From: Jonathan Best <Jonathan.Best@arun.gov.uk>
Sent: 21 May 2026 11:55
To: Planning.Responses <Planning.Responses@arun.gov.uk>
Cc: Amber Willard <Amber.Willard@arun.gov.uk>
Subject: BR/53/26/PL

57 Queensway Bognor Regis PO21 1QN.

I have reviewed this application with regards to ecology.

Front & Rear Elevations

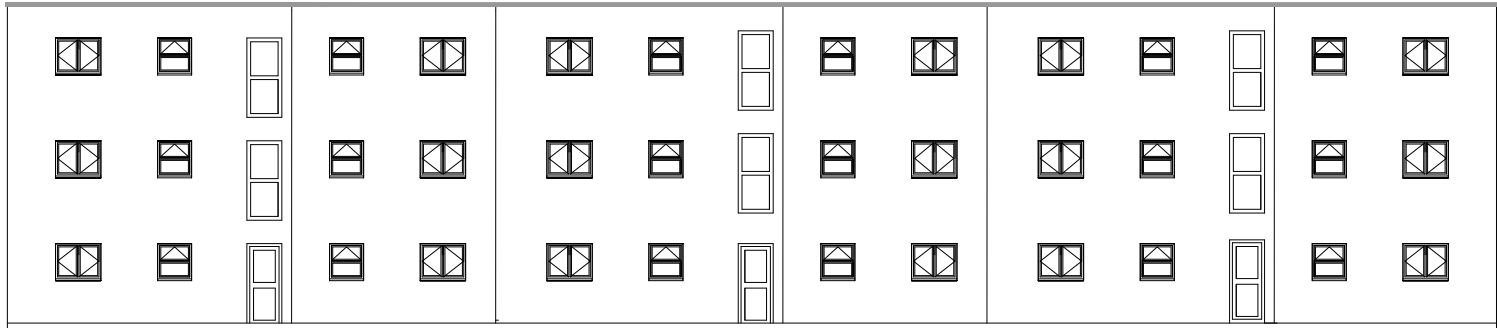
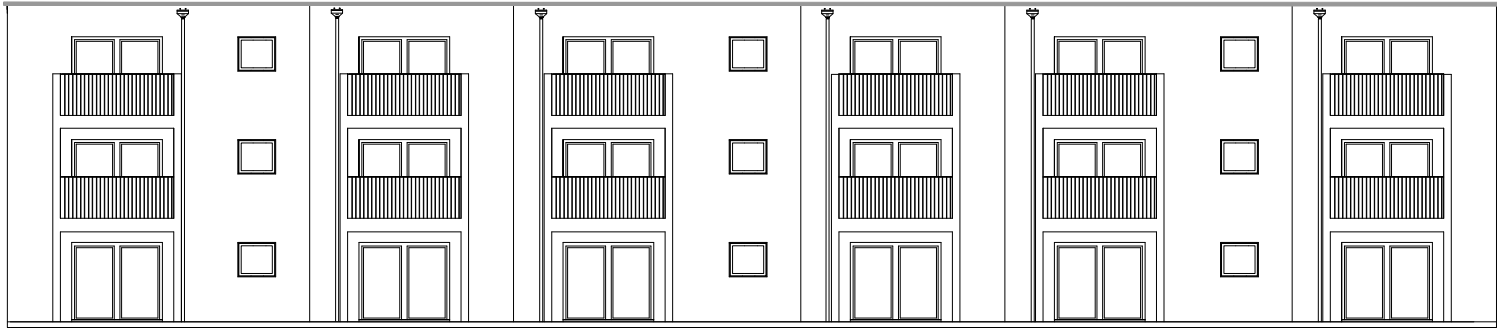
The current site has negligible ecological value. No ecological surveys are required.
A biodiversity statement has been provided. This statement has not been supported with any plans to show the proposed enhancements.
Nest boxes on trees will not be feasible as the trees will be too small to accommodate/support the boxes.
Native planting for trees and hedges is advised to support the birds nesting in the boxes.
Installing integral swift bricks and integral bat bricks or tubes is recommended.

ECOBNG2 – to include 6 integral swift bricks on the front of the flats and 6 bat tubes or bricks on the rear of the flats and plans of soft landscaping and tree planting that benefits nature.
